City of Portland, Maine - Building or Use Permit Application

Permit No: 02-1230	Issue Date: OCT 29 2002	CBL: 085 K002001
-----------------------	-----------------------------------	---------------------

Proposed Project Description:
build detached 5 x 8 outdoor shower

Cross section showing shower and dressing area
 2x4 Rafter @ 16" or 24" o.c.
 WITH 2
 skylights

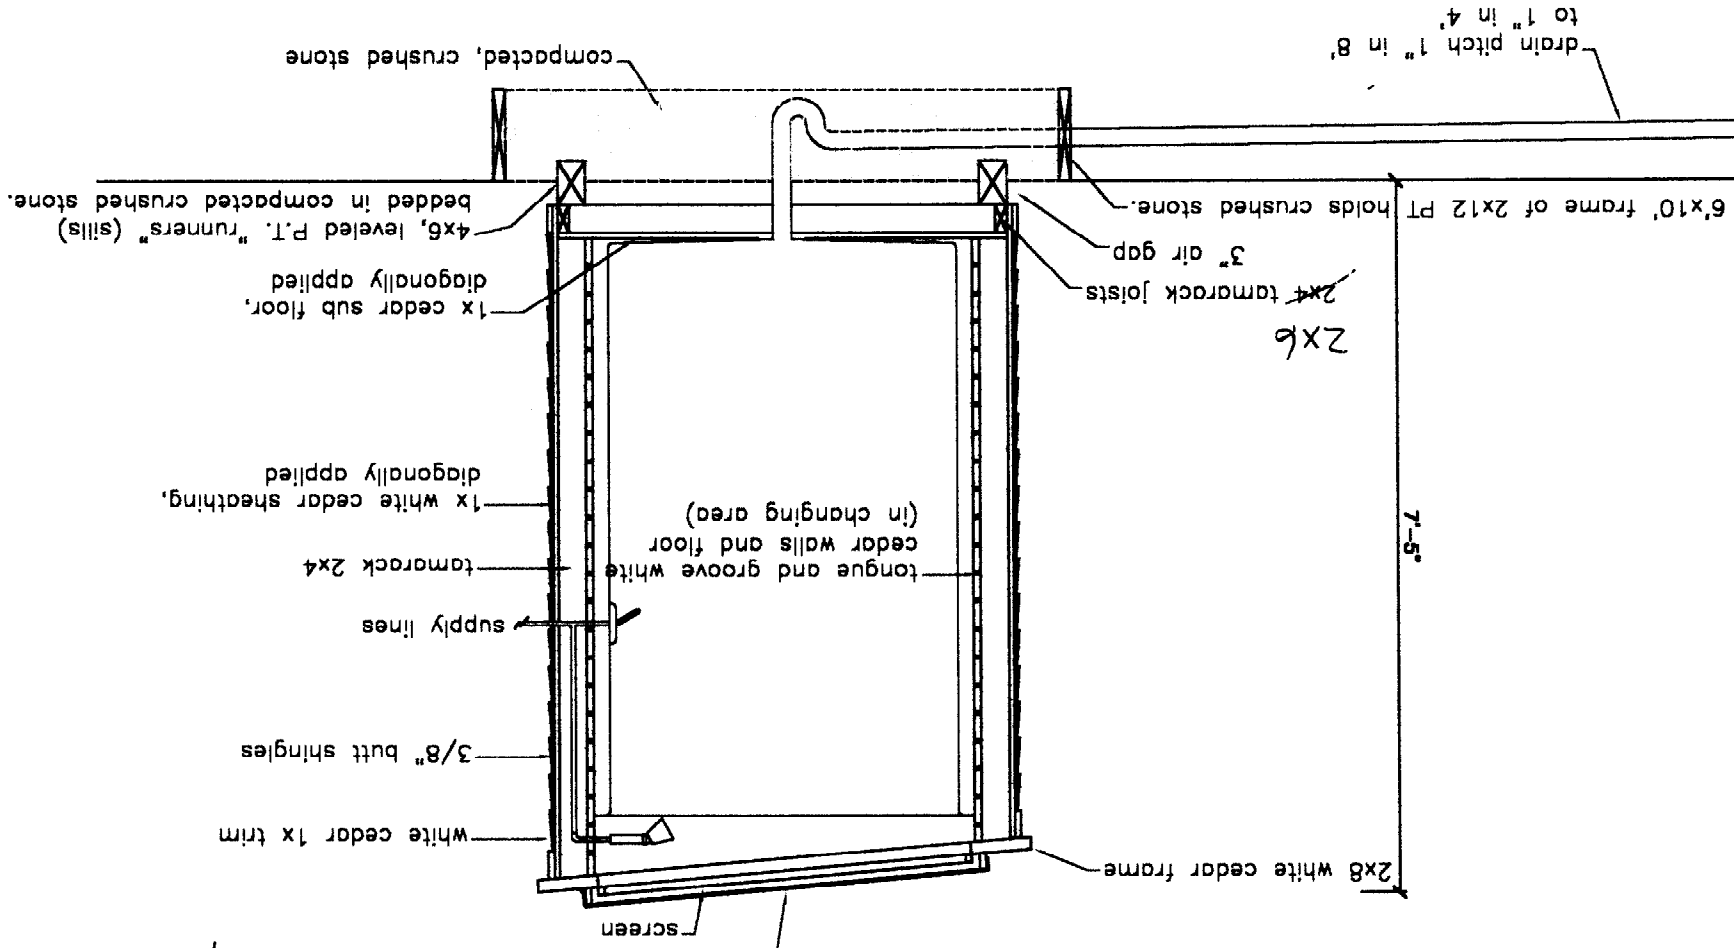
Floor joists must be 2 x 6, change in roof system to install 2 skylights with 2x4 rafters
